Application No. H14/0357/03/A1
Date Registered 22 JUL 2003
Case Officer PJU

PROPOSED EXTENSION AND WORKS
TO HOUSE AND ADJ. BARN.

Amendment: Increase width of rear extension & replace utility window with back door.

TOWN AND COUNTRY PLANNING ACT 1990 NOTICE OF ACCEPTANCE OF AMENDMENT

South College Farm Cottage, Buildings and Land, West Pinchbeck

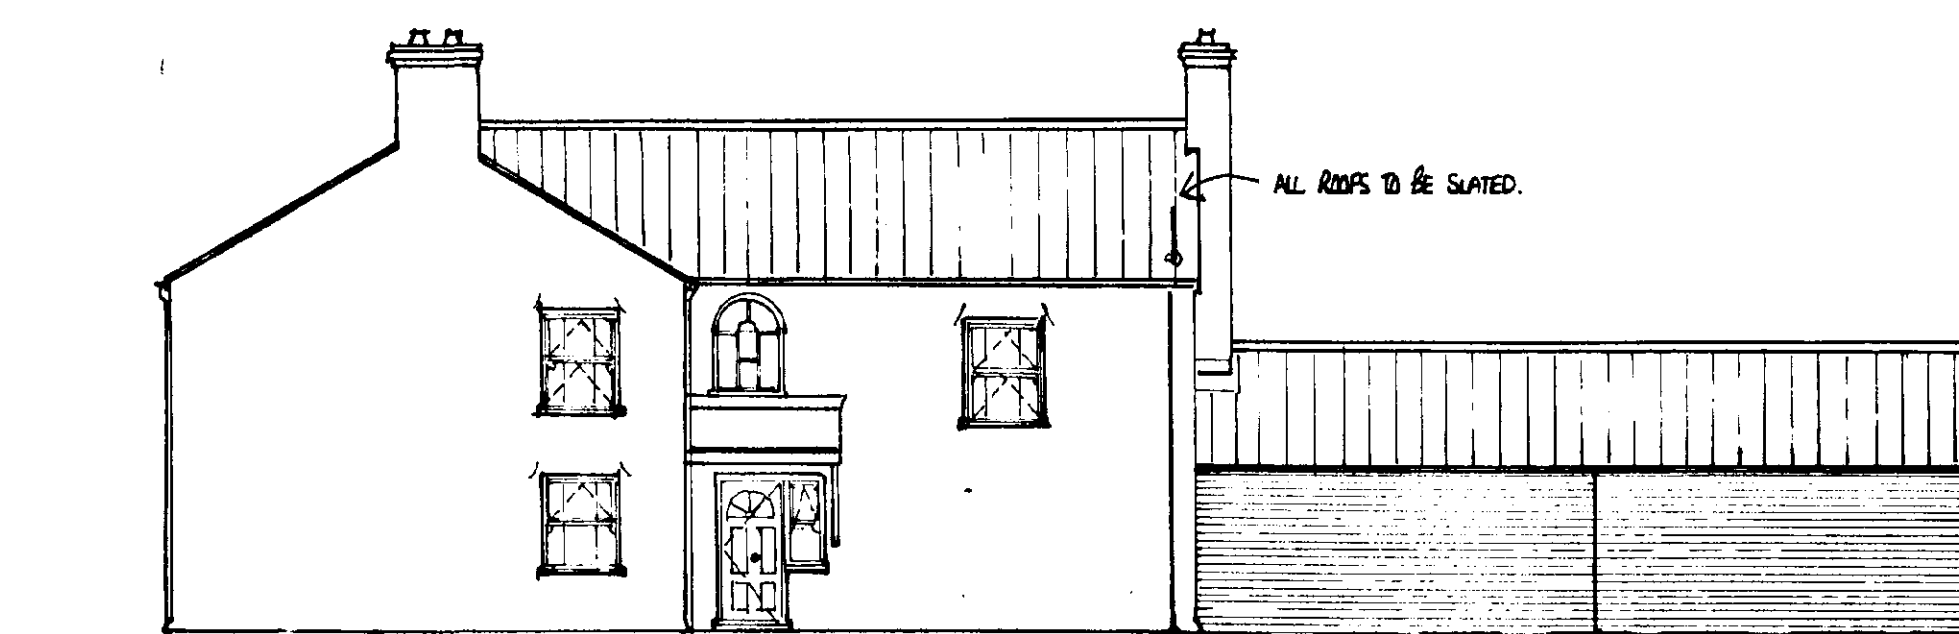
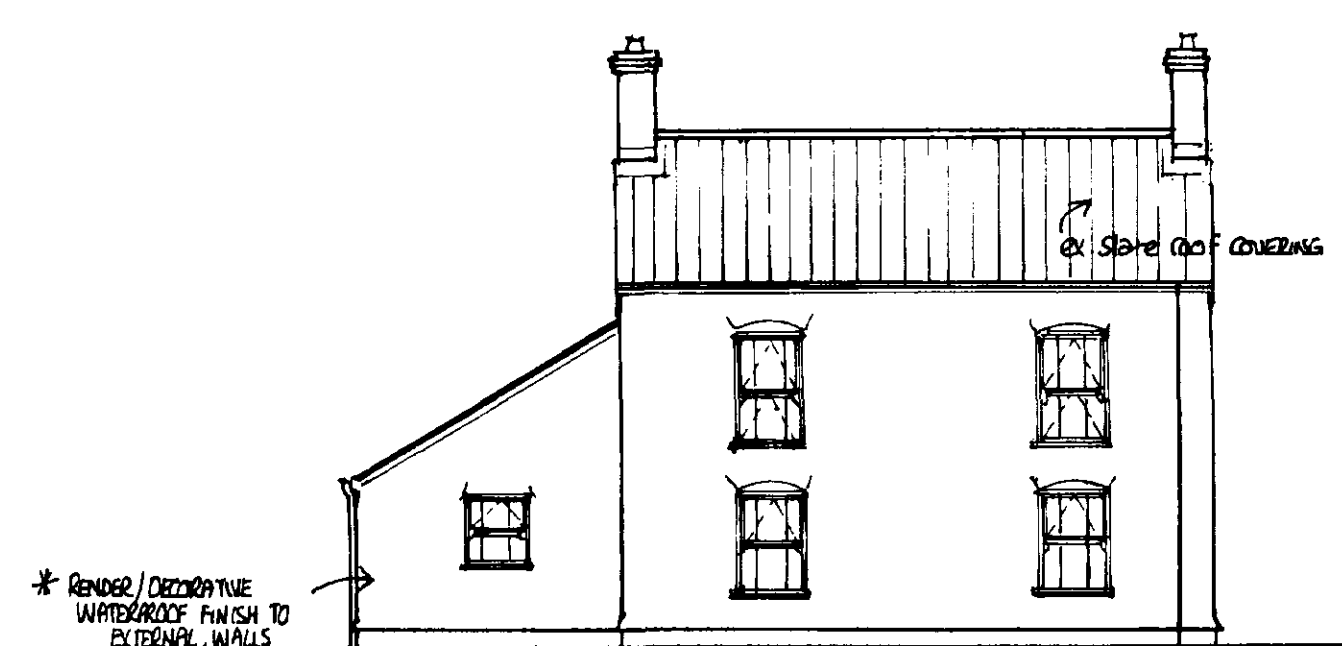
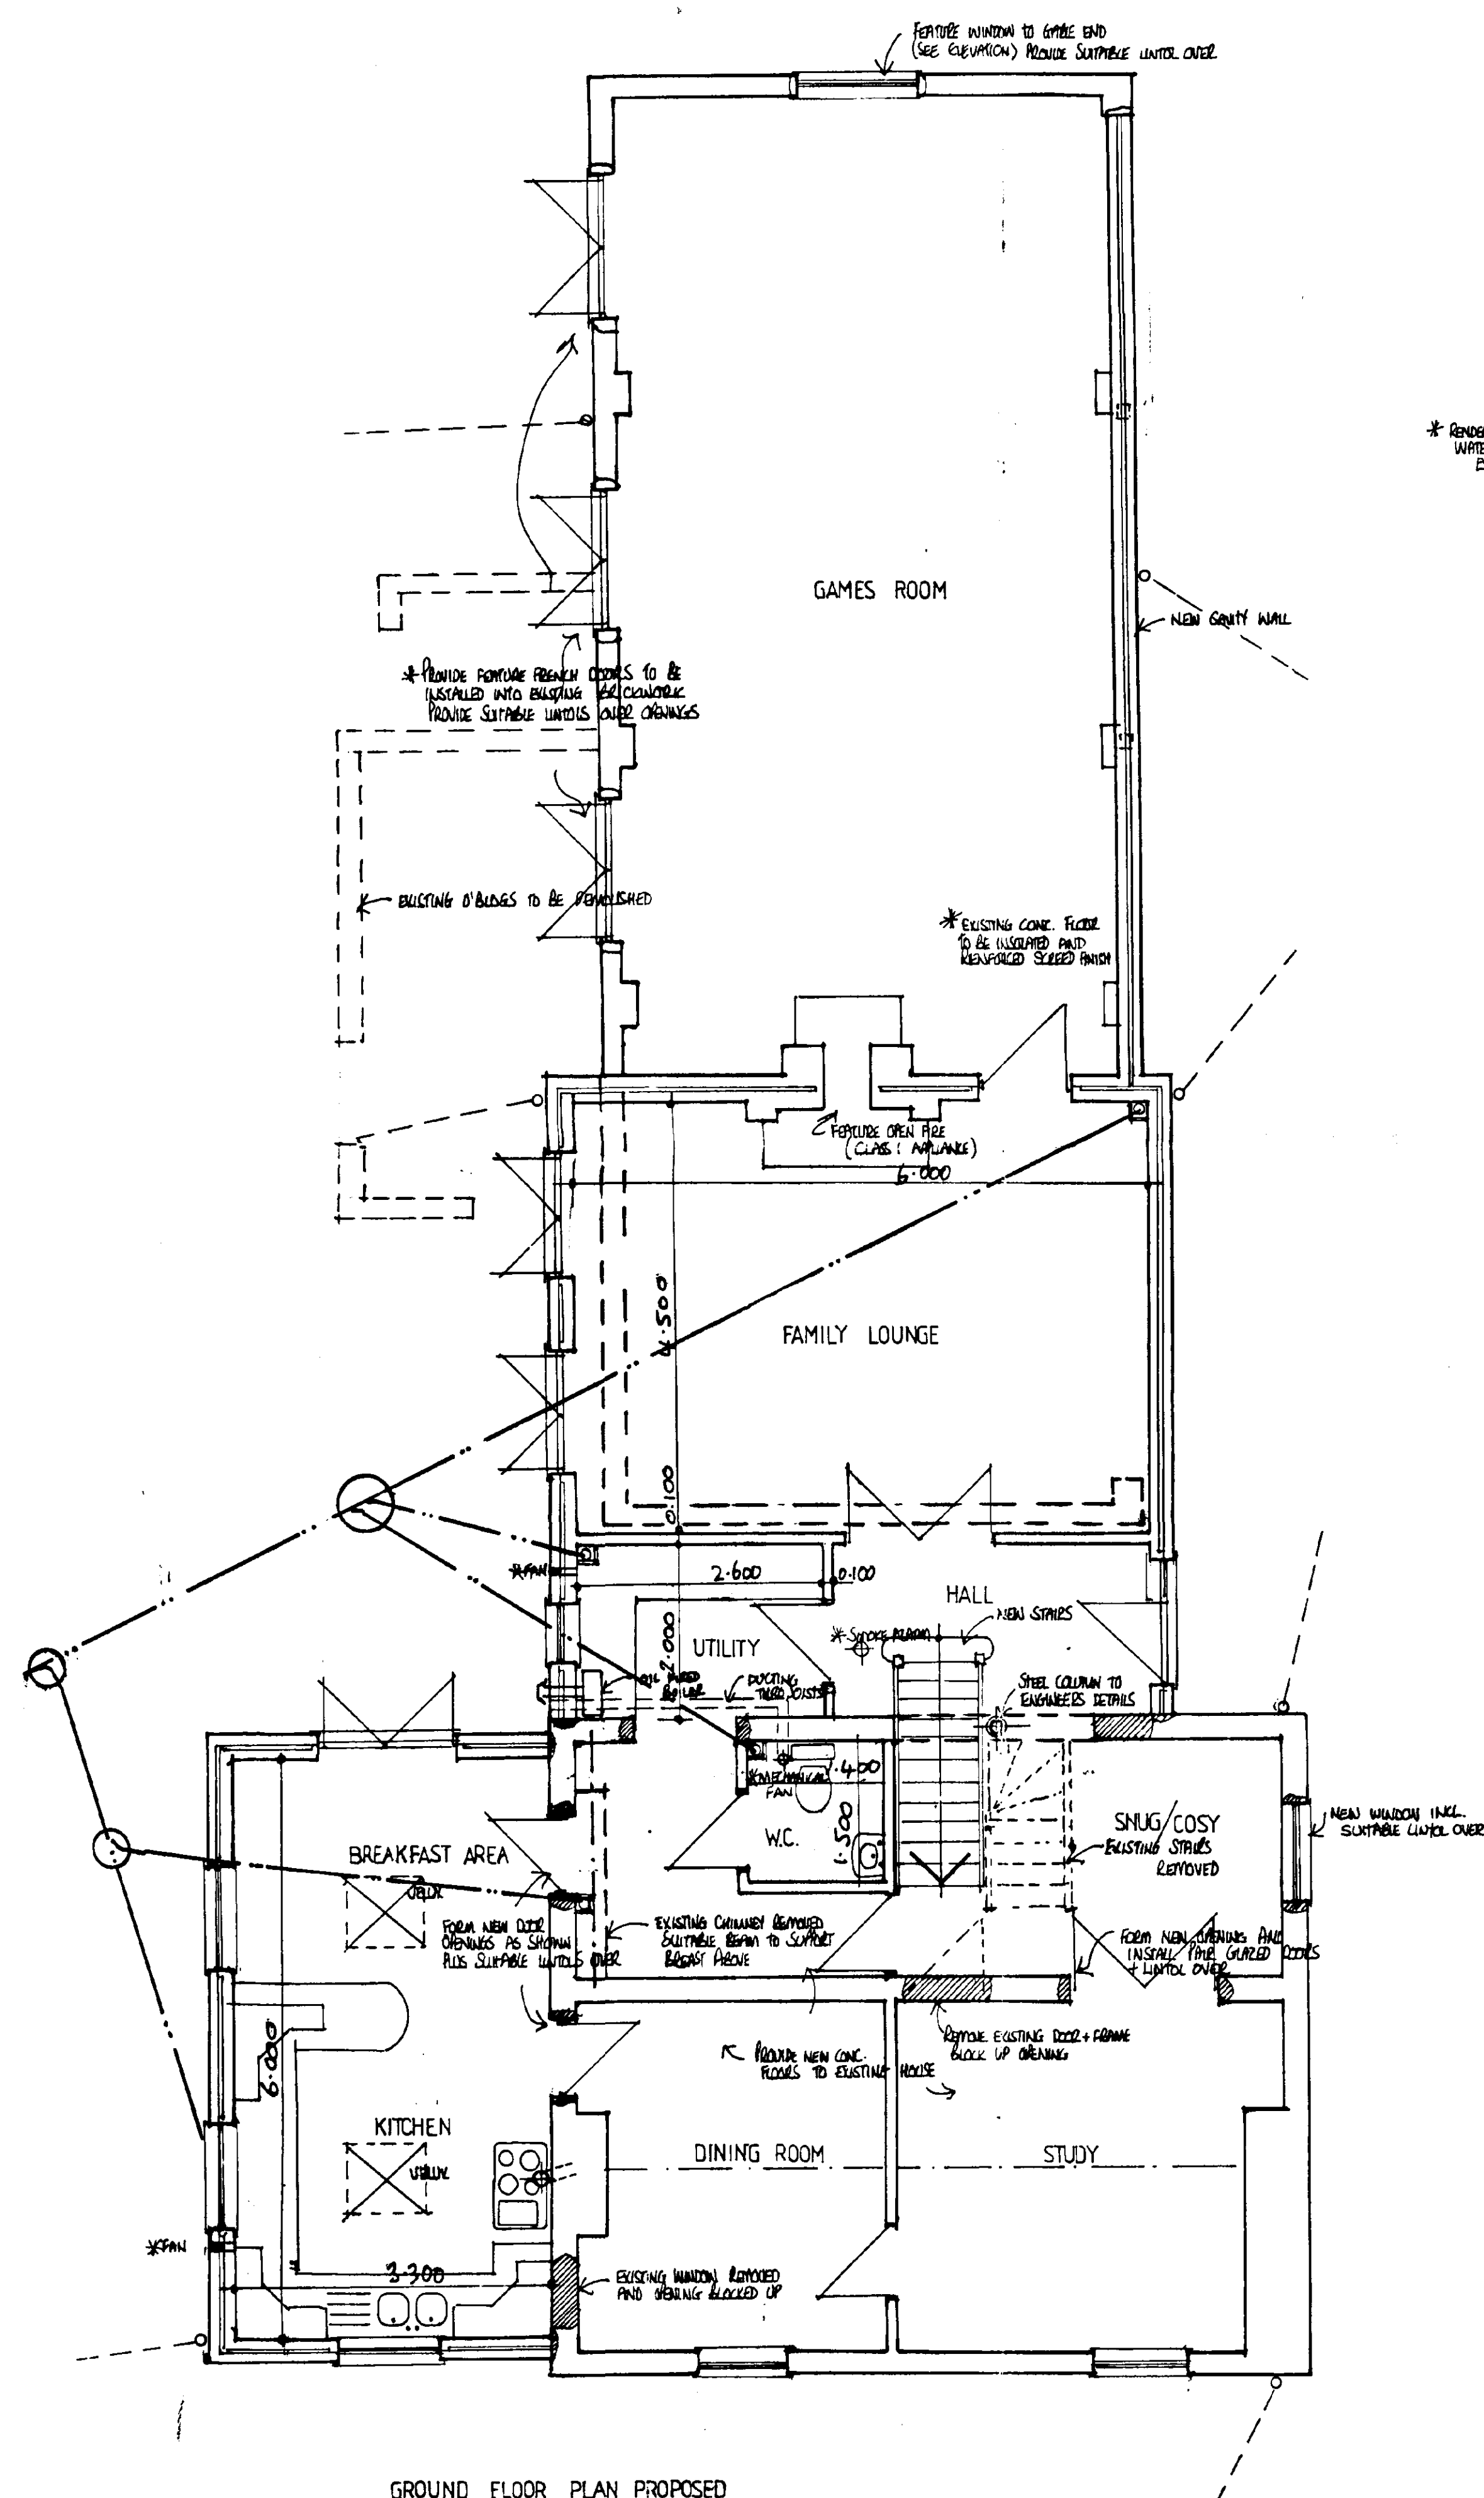
WIDTH OF REAR EXTENSION
INCREASED.
WINDOW TO UTILITY REPLACED
WITH BACK DOOR.
